Our ref: NO/2012/104433/01-L01
Your ref: 3/2012/0876

Date: 02 November 2012

**DEVELOPMENT OF 3 HOUSES LAND OFF VICTORIA TERRACE, MELLOR
BROOK, BLACKBURN.**

proposed new stream crossing 1 : 50

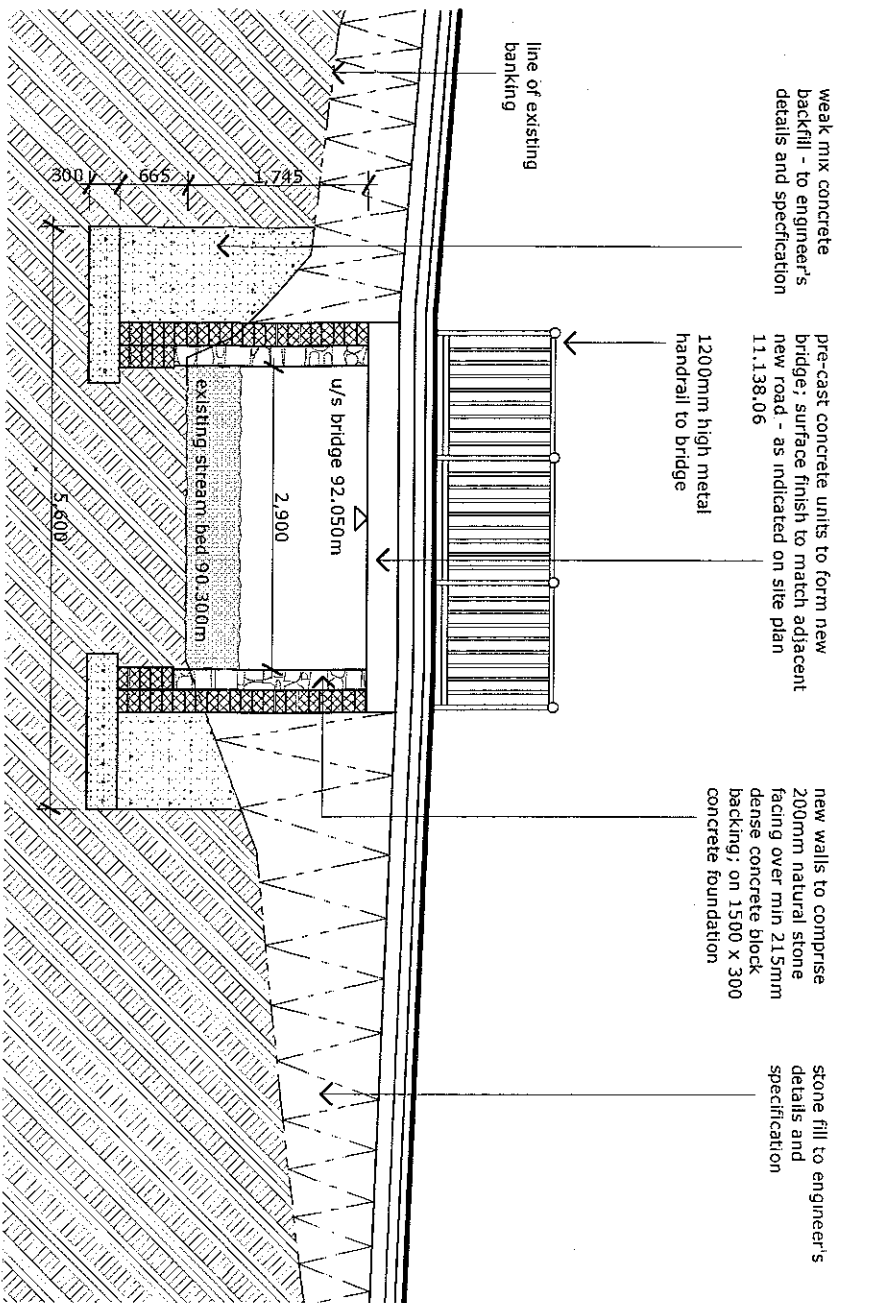
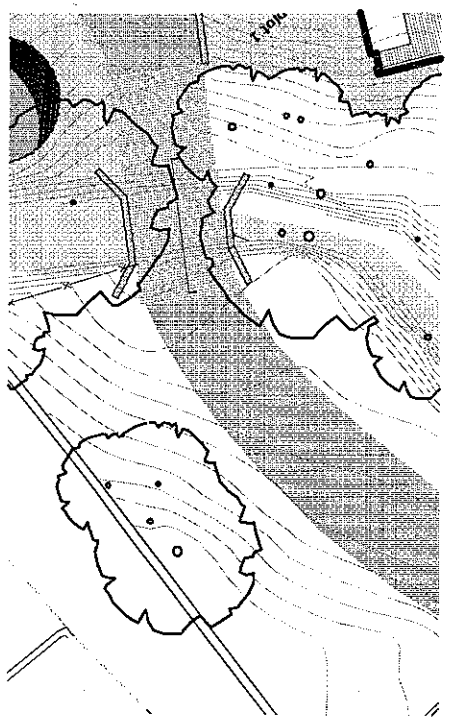
We object to the proposed development as submitted because the assessment of the risks to nature conservation is inadequate and no mitigation measures have been proposed. In particular, section 4.2.2 of the Extended Phase 1 Habitat Survey and Baseline EIA dated September 2012 refers to the partial loss of aquatic habitat due to the construction of a culvert, this loss of aquatic habitat has not been mitigated for.

The applicant should submit revised and detailed information which explains how the losses to and potential negative impacts on the aquatic environment will be avoided or where this is not possible, will be mitigated and compensated for.
